PLANNING CONSULTATION RESPONSE

| Proposal | Outline development of four residential dwellings and associated infrastructure considering access and layout (Custom/Self Build) |
| Address | Land to the rear of 31 Mansfield Road, Athersley North, Barnsley |
| Consultee | Highway Drainage |

SITE PLAN
SCALE 1:200

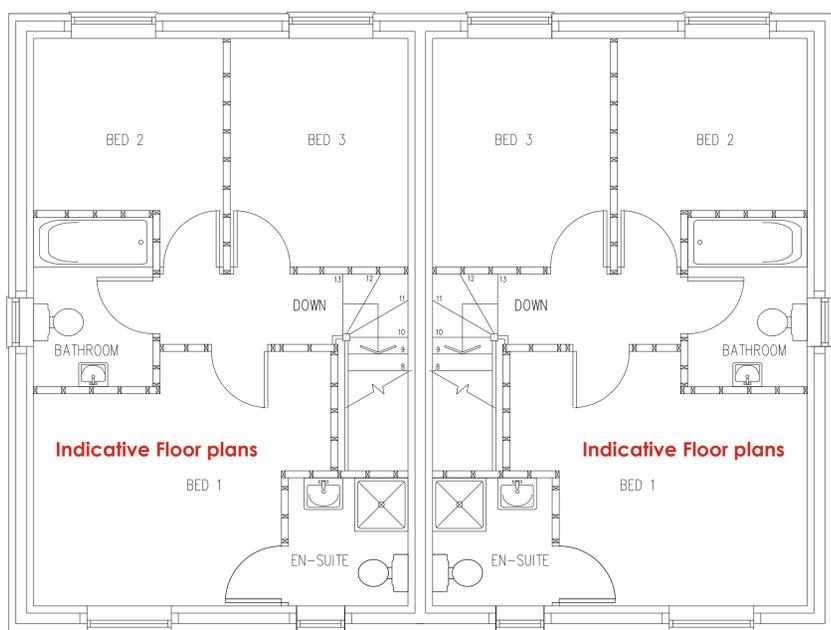
There are no drainage details shown on the plans submitted, with the application form describing foul to discharge to “Unknown” and surface water to “Unknown”, Whilst this is not very helpful in allowing me to make constructive comments, due to the limited scope of the works and the fact that the area is well served by sewers, I consider that a conditional approval is appropriate in this case.

Please ensure Yorkshire Water are consulted over the 225mm/150mm Foul Sewer that crosses this site. They will need to set the diversion or easement required for this apparatus

H4 - No development shall take place unless and until

(a) Full foul and surface water drainage details have been submitted to and approved in writing by the Local Planning Authority. Thereafter no part of the development shall be occupied or brought into use until the approved scheme has been fully implemented. The scheme shall be retained throughout the life of the development unless otherwise agreed in writing with the Local Planning Authority.

(b) Porosity tests are carried out in accordance with BRE 365, to demonstrate that the subsoil is suitable for soakaways and

(c) Calculations based on the results of these porosity tests to prove that adequate land area is available for the construction of the soakaways are all approved in writing by the Local Planning Authority. @ To ensure the proper drainage of the area
